## Jeanie Bourke - Re: 129 Spring St., BP#2014-02913 plan review comment

**From:** Jeanie Bourke  
**To:** HOME Catering Co.  
**Date:** 2/12/2015 1:50 PM  
**Subject:** Re: 129 Spring St., BP#2014-02913 plan review comments

# HOME Catering Co. 129 Spring Street Portland, ME 04101

129 Spring St. Proposed Floor Plan

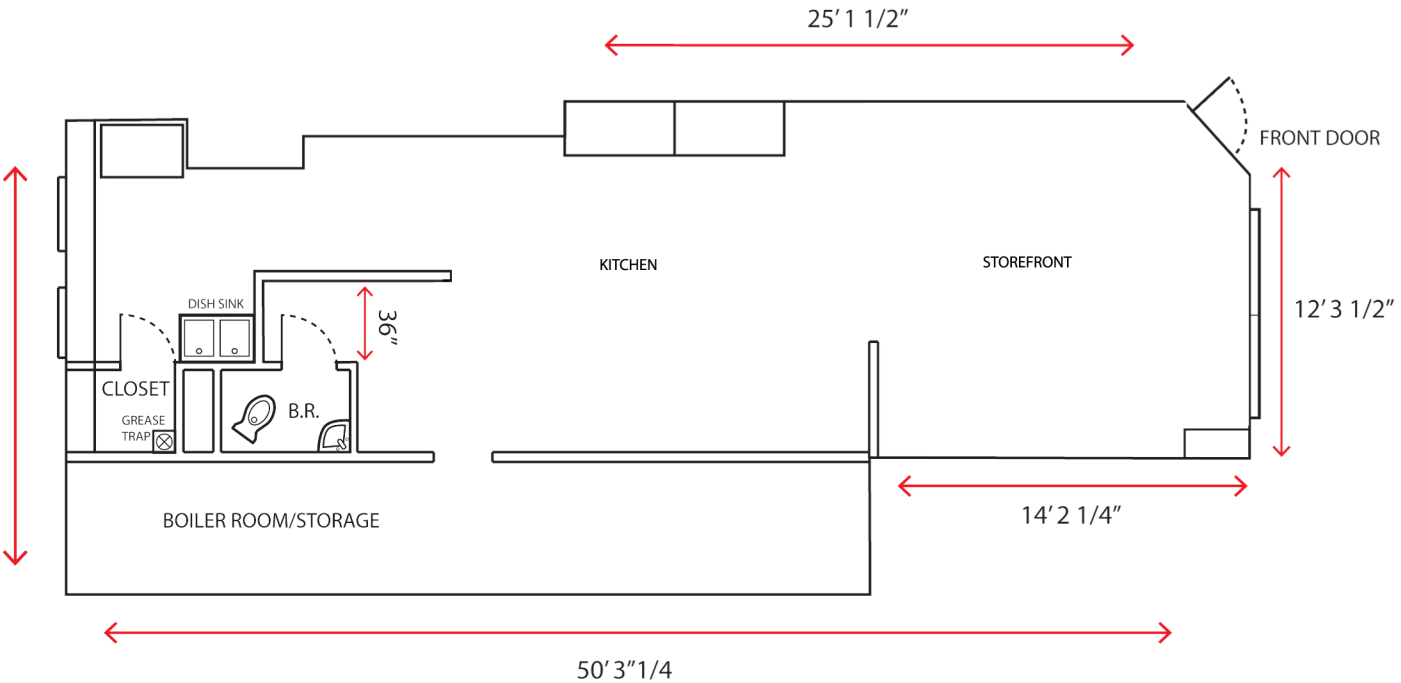
1. Is there a currently a suppression hood? If not, this is required for grease vapors and though a separate permit is required, this will also need to be included for this permit exhaust location and for historic review.

2. Have you consulted with the Public Health inspectors for fixture requirements, speci Date: 02/17/15  
bay sink?

Thanks for the clarification. The hood requirement is based on products cooked and if grease vapors are created, not if the equipment is electric or gas. There certainly are gas venting/exhausting requirements as well.

You should consult with the fire department on the need for the hood/suppression requirement. You can contact Craig Messinger at [crm@portlandmaine.gov](mailto:crm@portlandmaine.gov) or 874-8400.

I will approve the permit based on the information you have provided. The permit appears to remain in review for historic preservation.

1. There is not currently a fire suppression hood as all equipment is electric and will be used for general heating of soups, bread, etc. A proposed menu was submitted to Health and Public Services on December 16th. All kitchen equipment and systems are the same as were in use at Miyake Diner and Food Factory Miyake.

2. I apologize for the sketch. I did my best to label the sink as a three bay, but I was unable to find the appropriate graphic to represent it as such on the plan. The sink is, in fact, a three bay sink and I have spoken with Frank Brancely at Public Services about it and the newly required grease trap which is on order.
